Planning Services Sign Permit Review Form

Date of Submittal	Application Number	Applicant	Landowner
10/26/2023	SIGN2310-0005	TMTLA Associates	DRB Group North Carolina LLC.

Contact Person	Robin@tmtia.com	Contact Number	919-484-8880
Sign Location	Corner of Sheriff Johnson Rd. and Bronze Leaf Dr.; Lots 88.	PIN Number	0680-38-7921.000

2 SIGN LOCATION PLAN B
SCALE: 1"=20'

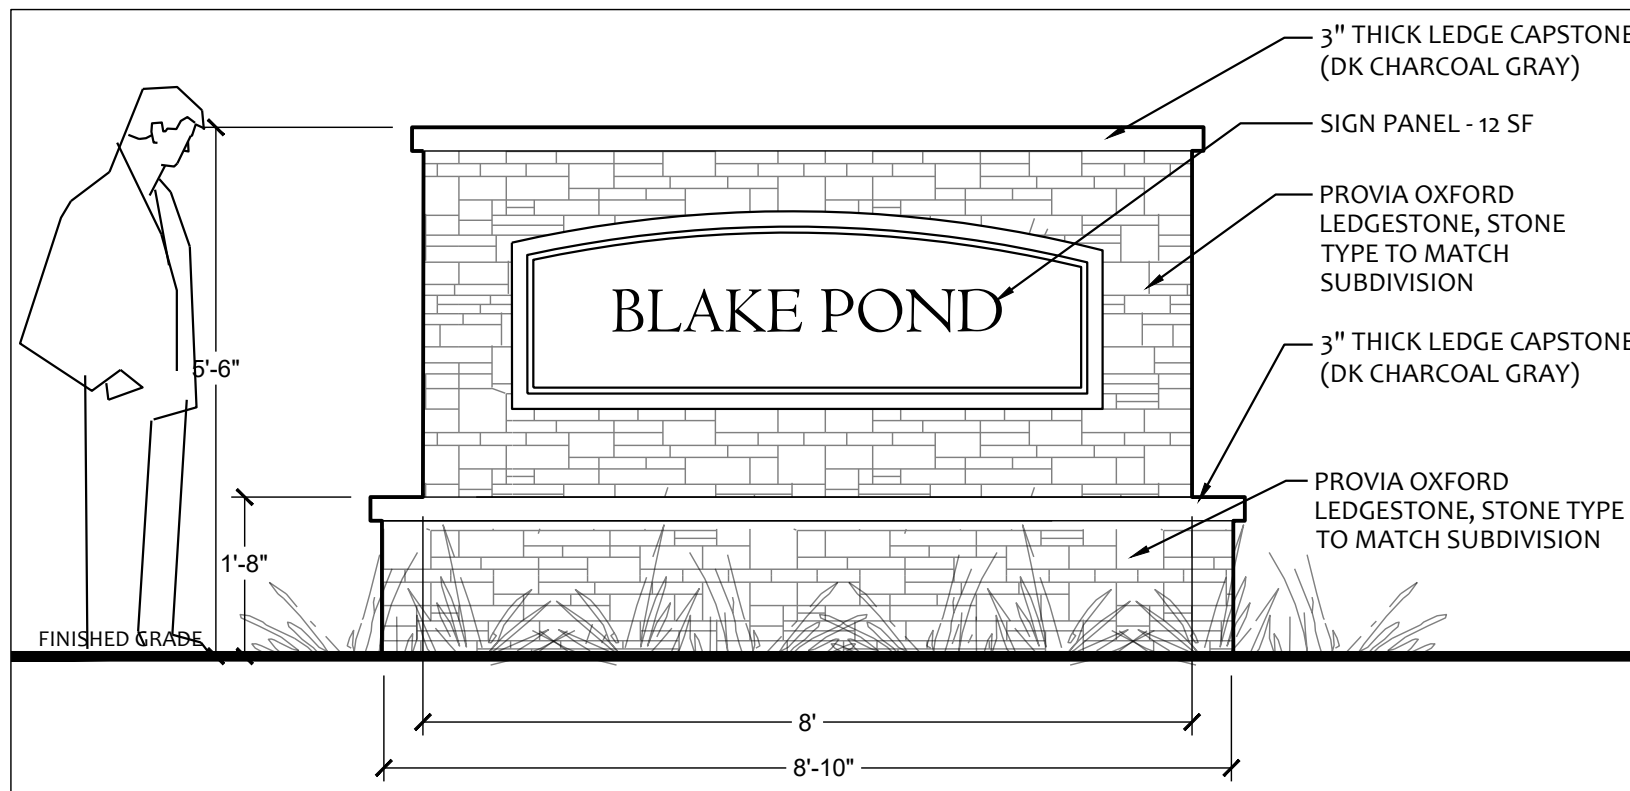
Comments	-Only the sign for Great Smokey Pl. & Sherriff Johnson road is being reviewed on this permit. The site plan shows two signs and, one on Bronze Leaf Rd., which is not a part of this permit as this section of the subdivision has not been platted at this time.
----------	---
